WEST SUSSEX COUNTY COUNCIL CONSULTATION

TO:	Arun District Council FAO: M Tomalova
FROM:	WSCC - Highways Authority
DATE:	28 March 2022
LOCATION:	107 Felpham Way Bognor Regis PO22 8QB
SUBJECT:	FP/31/22/PL Construction of a pair of semi-detached dwellings with electric mobility scooter/cycle & refuse storage facilities. This site is in CIL Zone 4 and is CIL Liable as new dwellings.
DATE OF SITE VISIT:	n/a
RECOMMENDATION:	Advice
S106 CONTRIBUTION TOTAL:	n/a

Project		Land to rear 107 Felpham, Bognor Regis	
Drawing		Sketch Site Plan	
Date	august 2021	Drawn by	
Scales	1:100 @ A1	Suitability	sketch
Doc No	DLS-031-SK-11-B	Revision	C

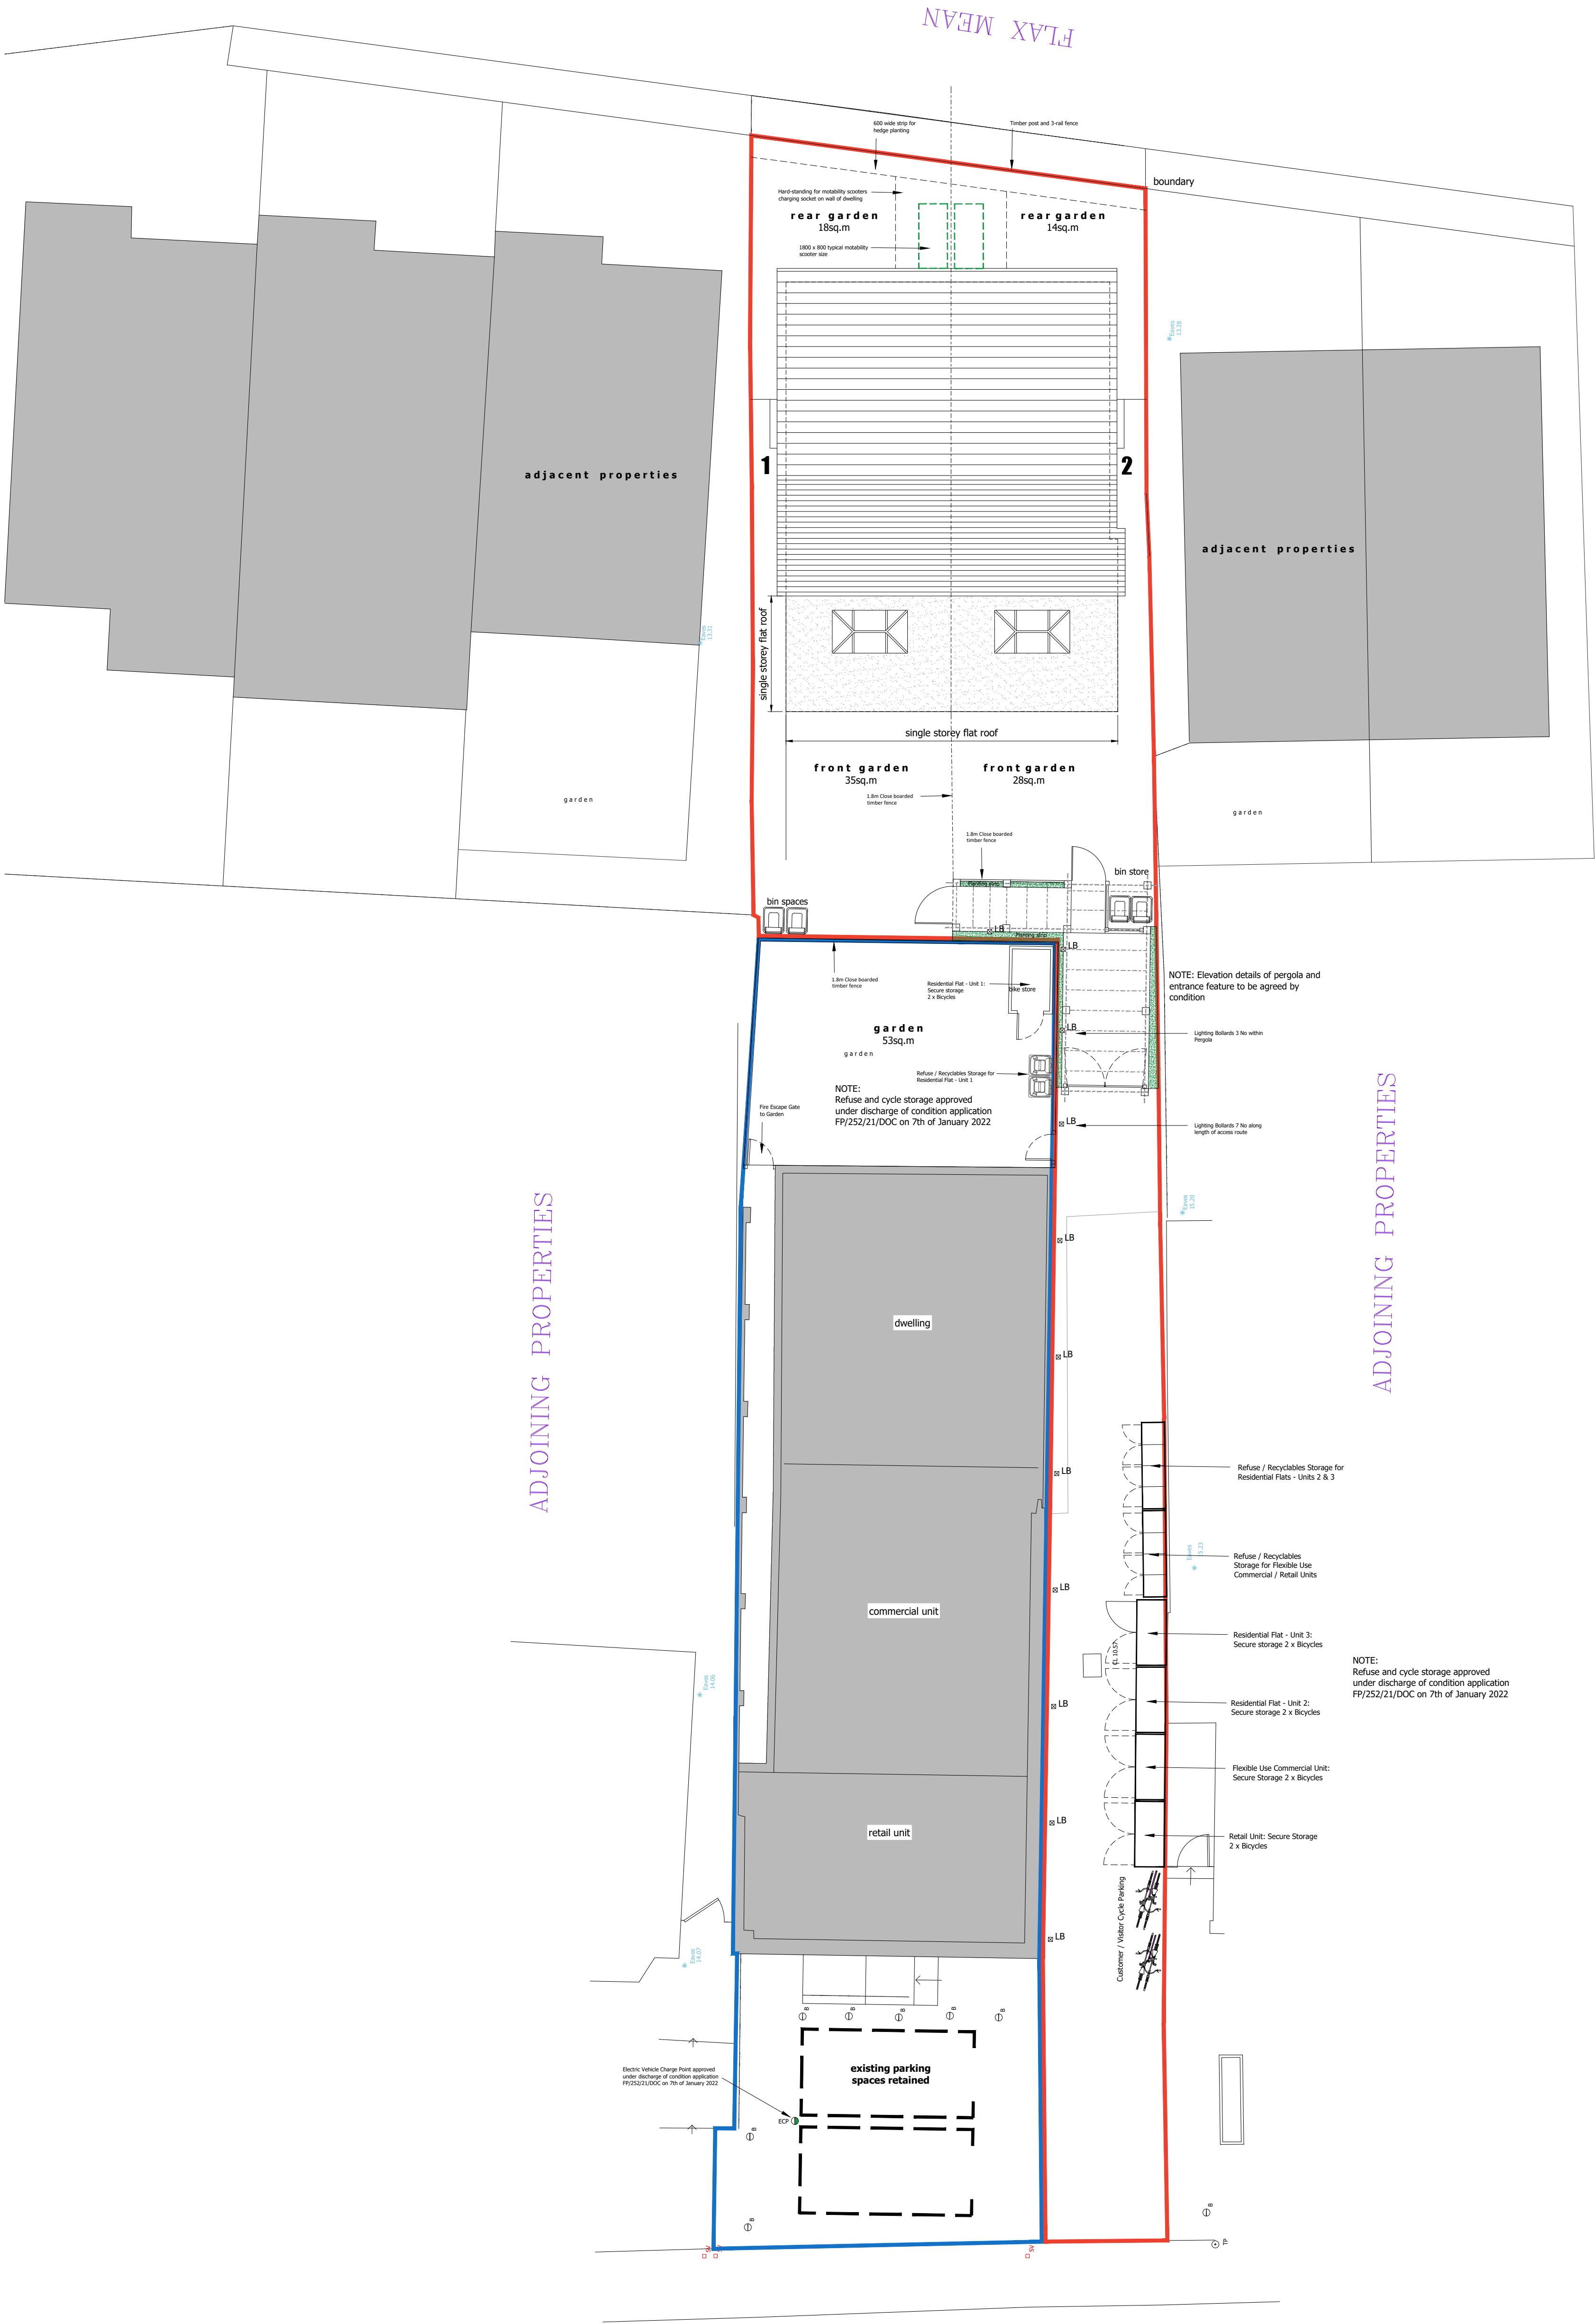
The provided plans demonstrate an existing footway access to the site and this is not being altered in any way. Nil parking is proposed to serve the proposed dwellings.

Cycle parking large enough to store 1 bicycle per dwelling should be provided. This provision should be secure and covered the details of which can be secured via a suitably worded condition.

No part of the development shall be first occupied until covered and secure cycle parking spaces have been provided in accordance with plans and details to be submitted to and approved by the Local Planning Authority.

Drawing No. 2021-6359-002	Rev. B
-------------------------------------	------------------

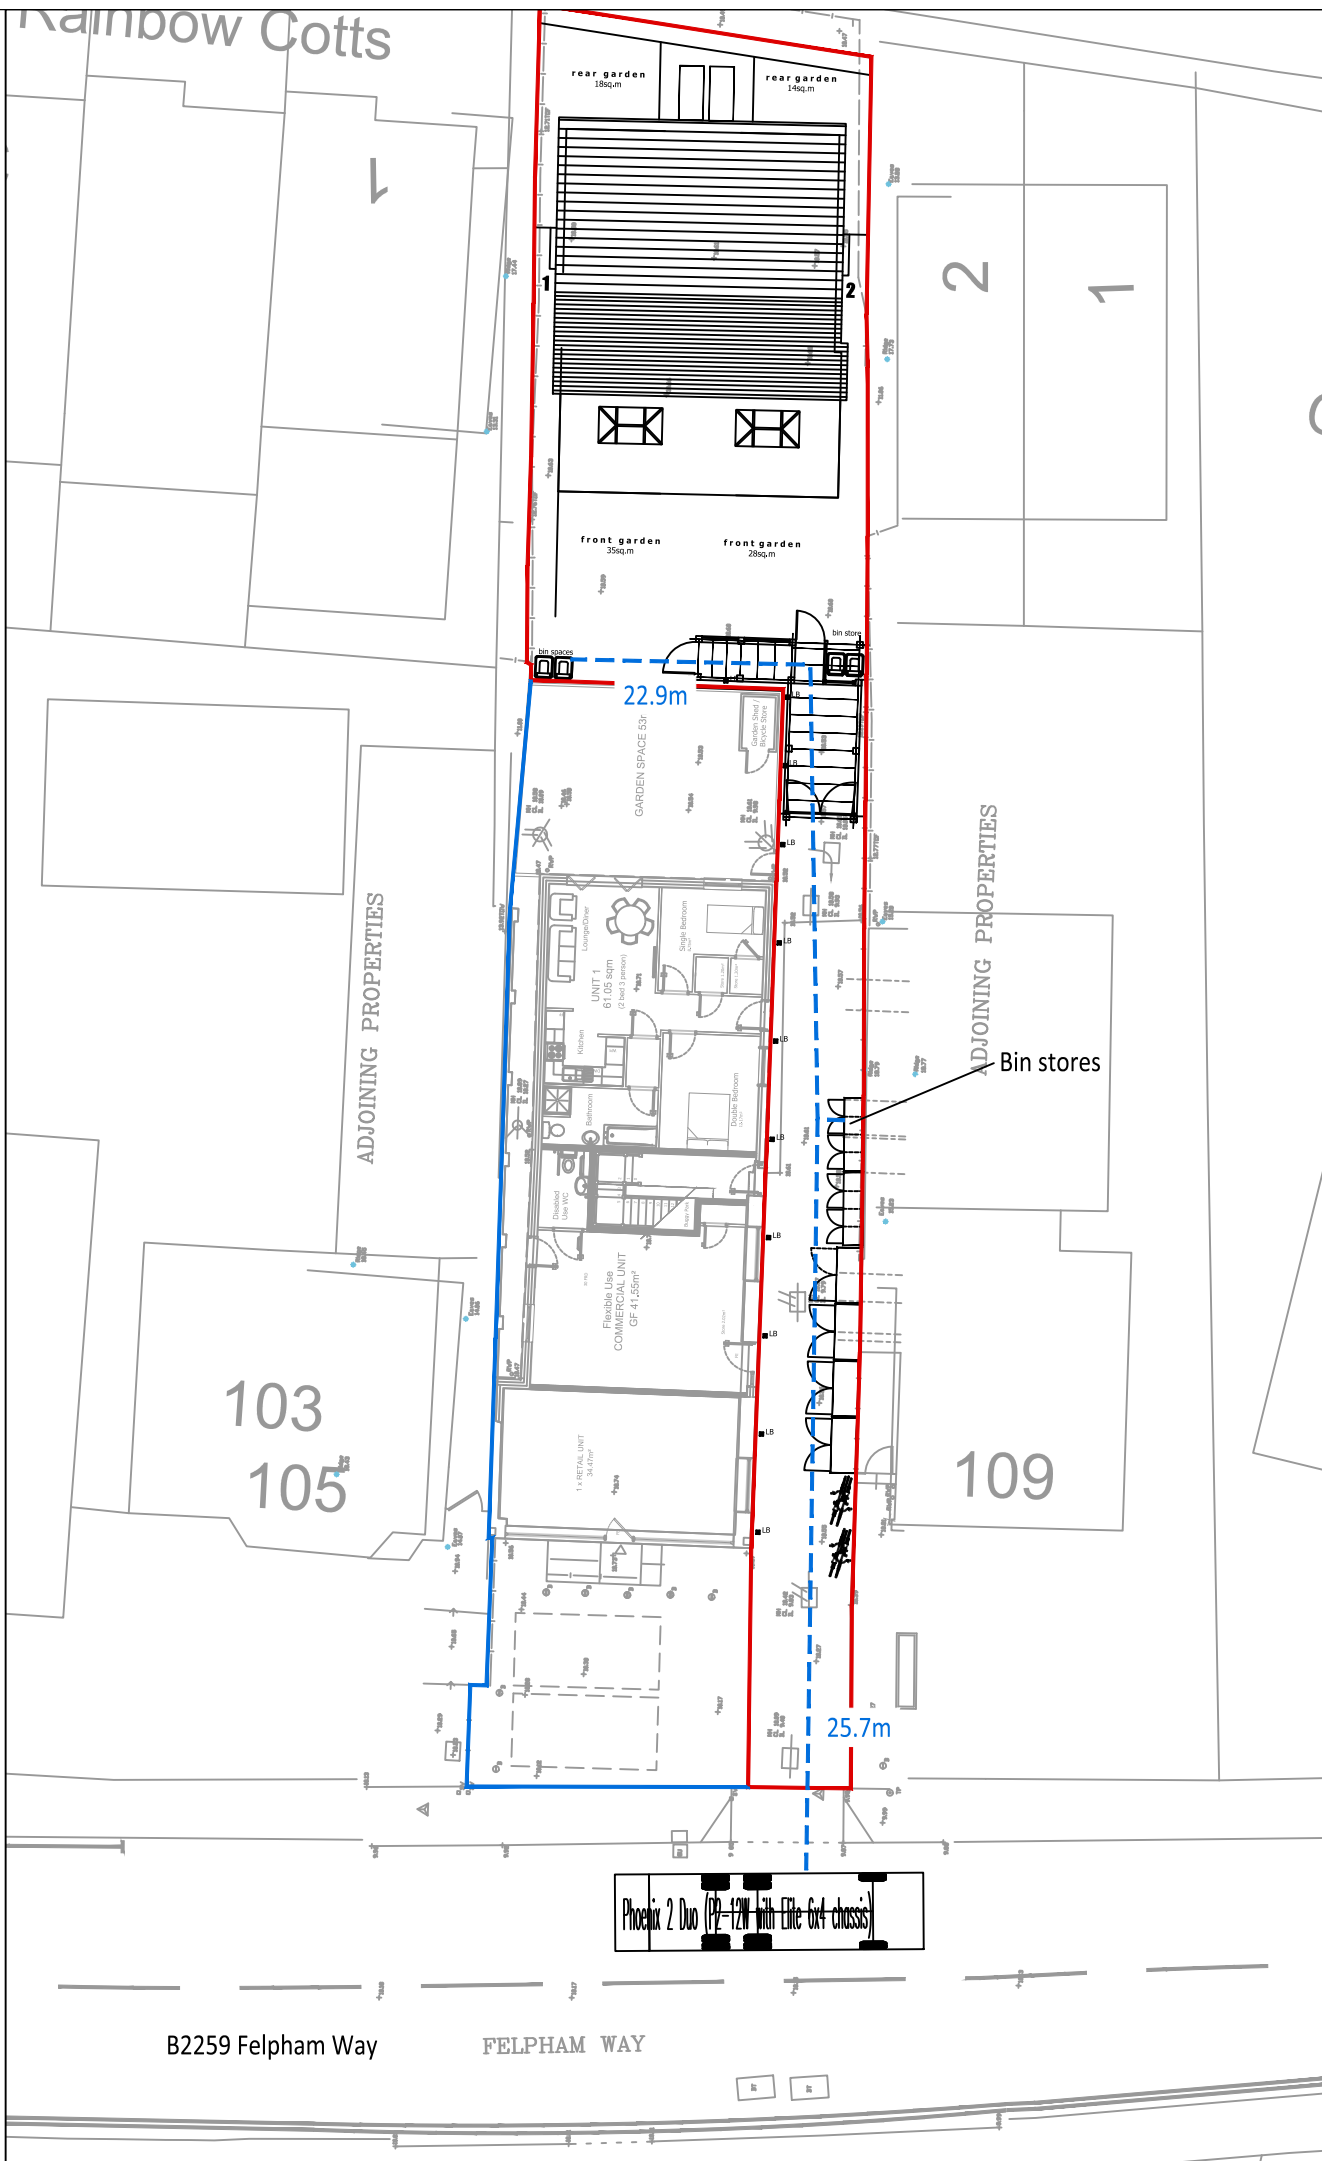
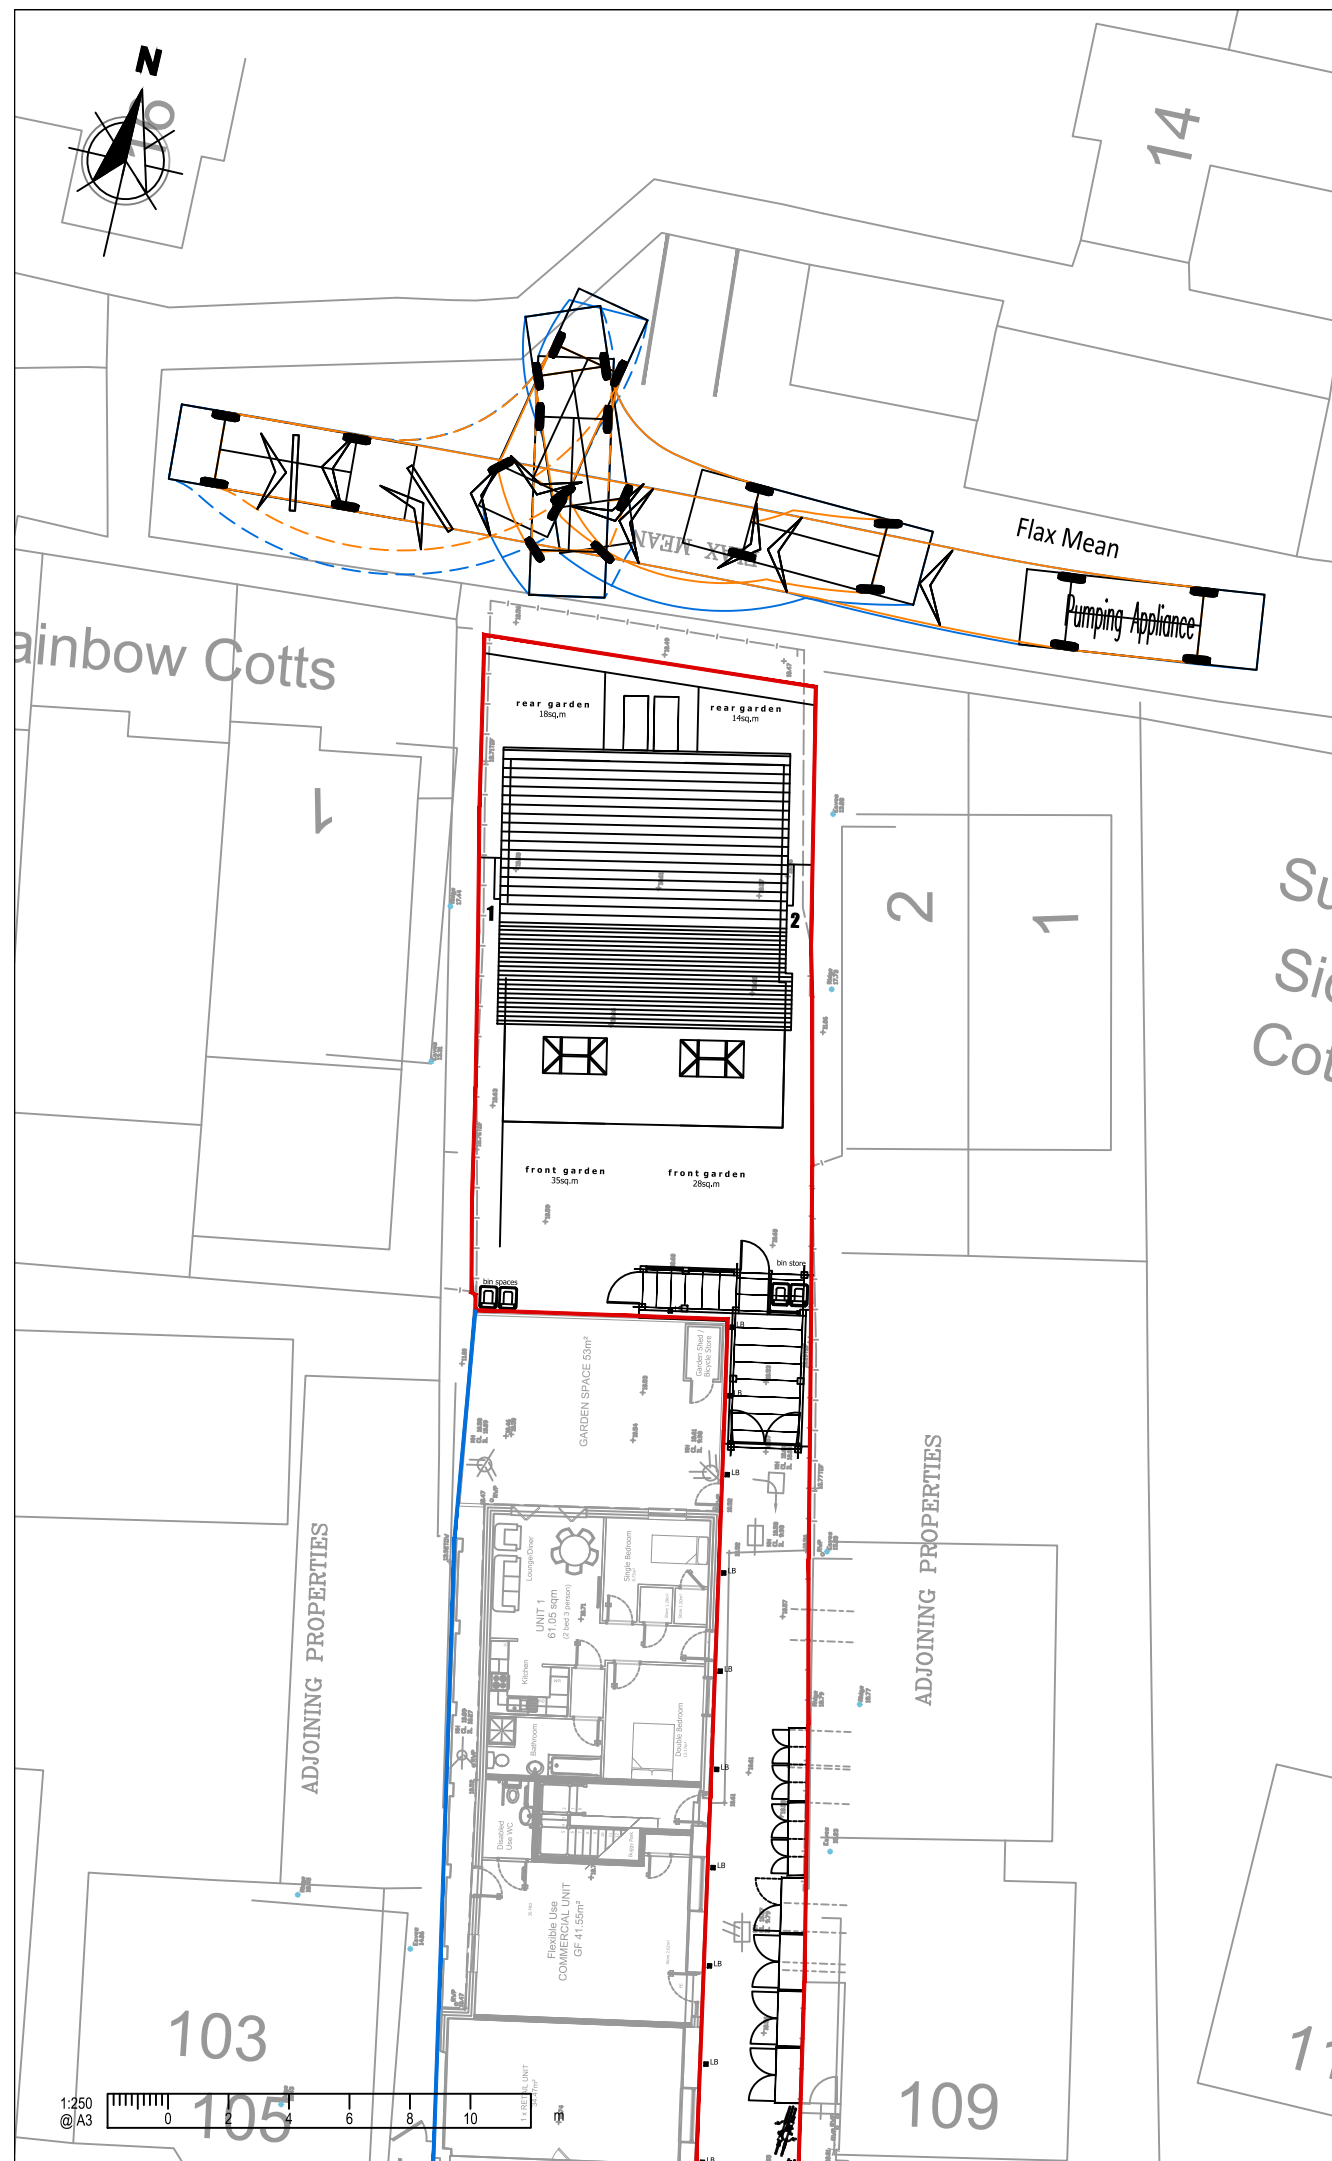
The applicants transport statement details that emergency fire access can be facilitated via Flax Mean which is a private road to the rear of the site. The local planning authority should consult with the WSCC water and access manager with regard to the suitability to this arrangement.

Refuse servicing is anticipated to take place from Felpham Way with a refuse vehicle waiting on Felpham Way while servicing takes place. Waste carry/collection distances have been demonstrated within the applicants transport statement. The refuse collection authority should be consulted with regards to the suitability of this arrangement.
